RE: Greenway Sewer Diversion 44457/APP/2021/2212 - Conditions

44457/APP/2021/4086

LIGHTING PLAN

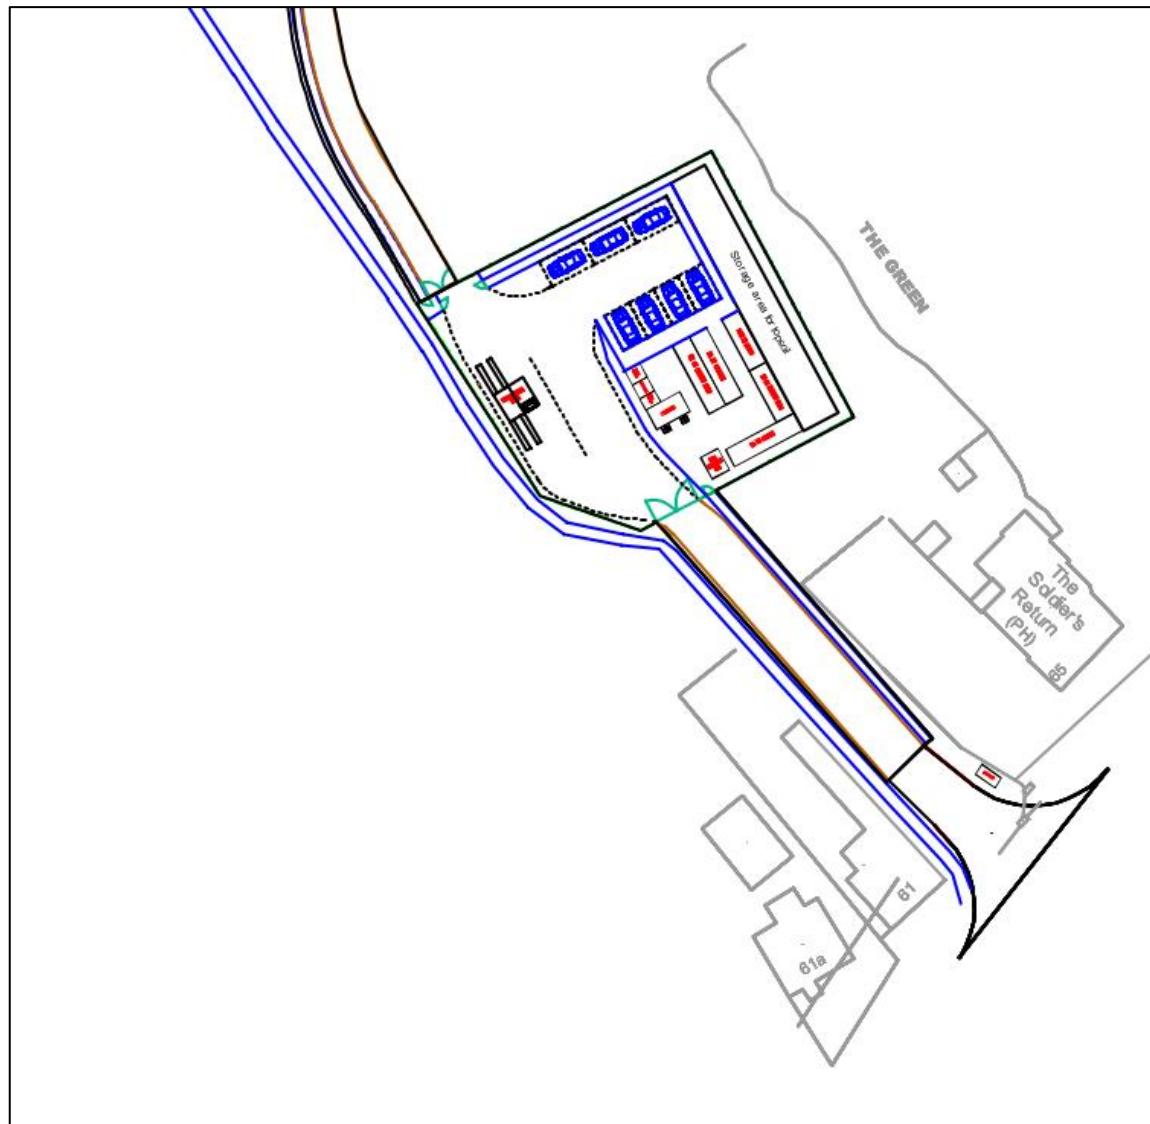
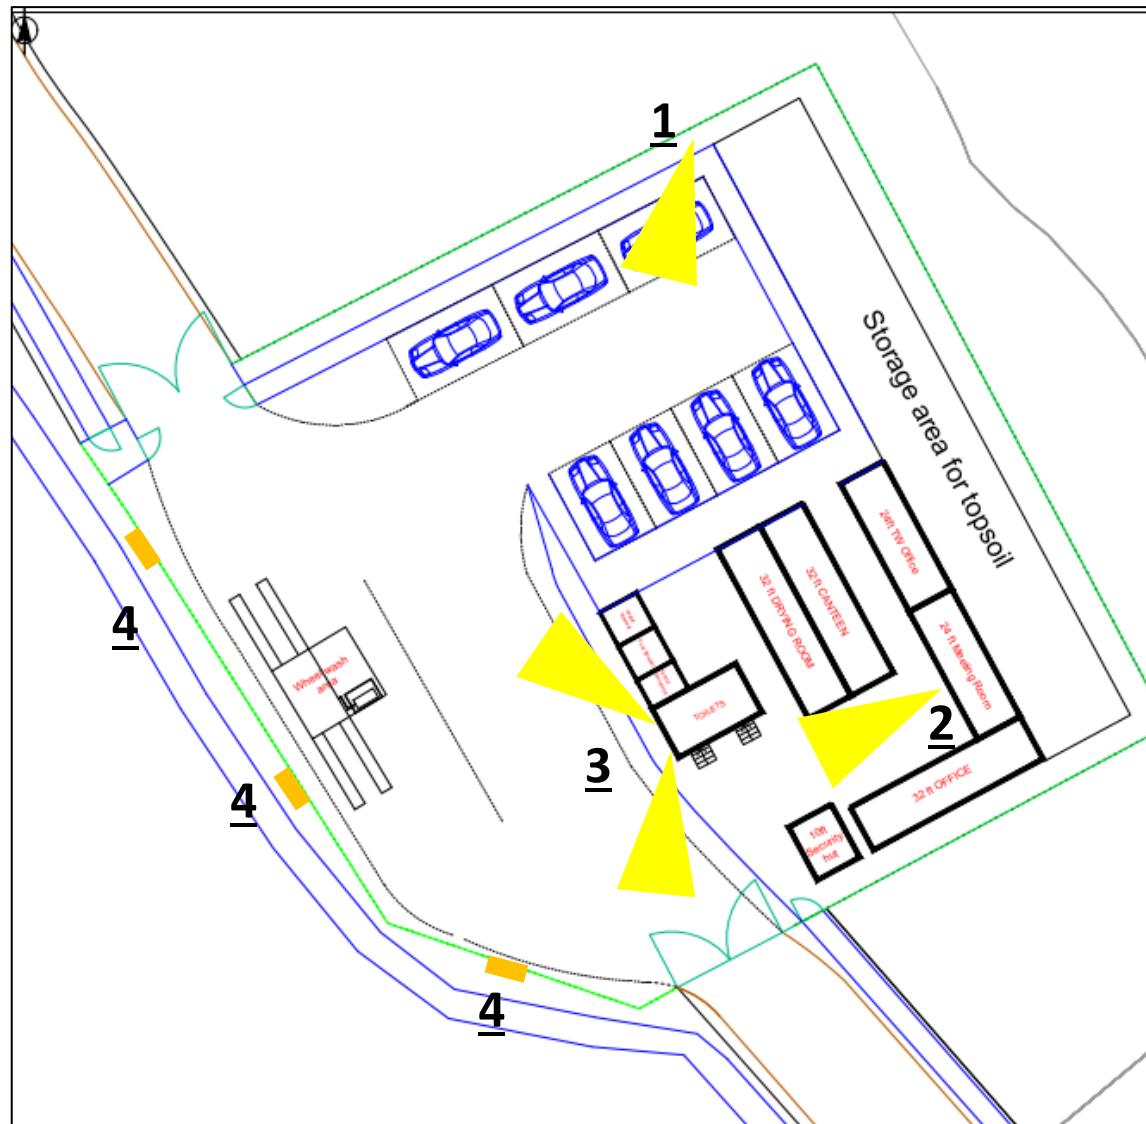
With regards to the proposed lighting, can you provide clarification on when all the lights will be on. There is only 1 annotation in the document about the hours of illumination for the tower lighting. Will be other lighting therefore be on 24/7?

The Lights in our compound area as per the below image will be on during the night time. This is where our security will be based.

The remainder of the fixed lights we will operate on a Sensor System, where they will illuminate if someone comes into the area.

(This is more for a security purpose in case someone unwanted enters the site and got injured in the excavations)
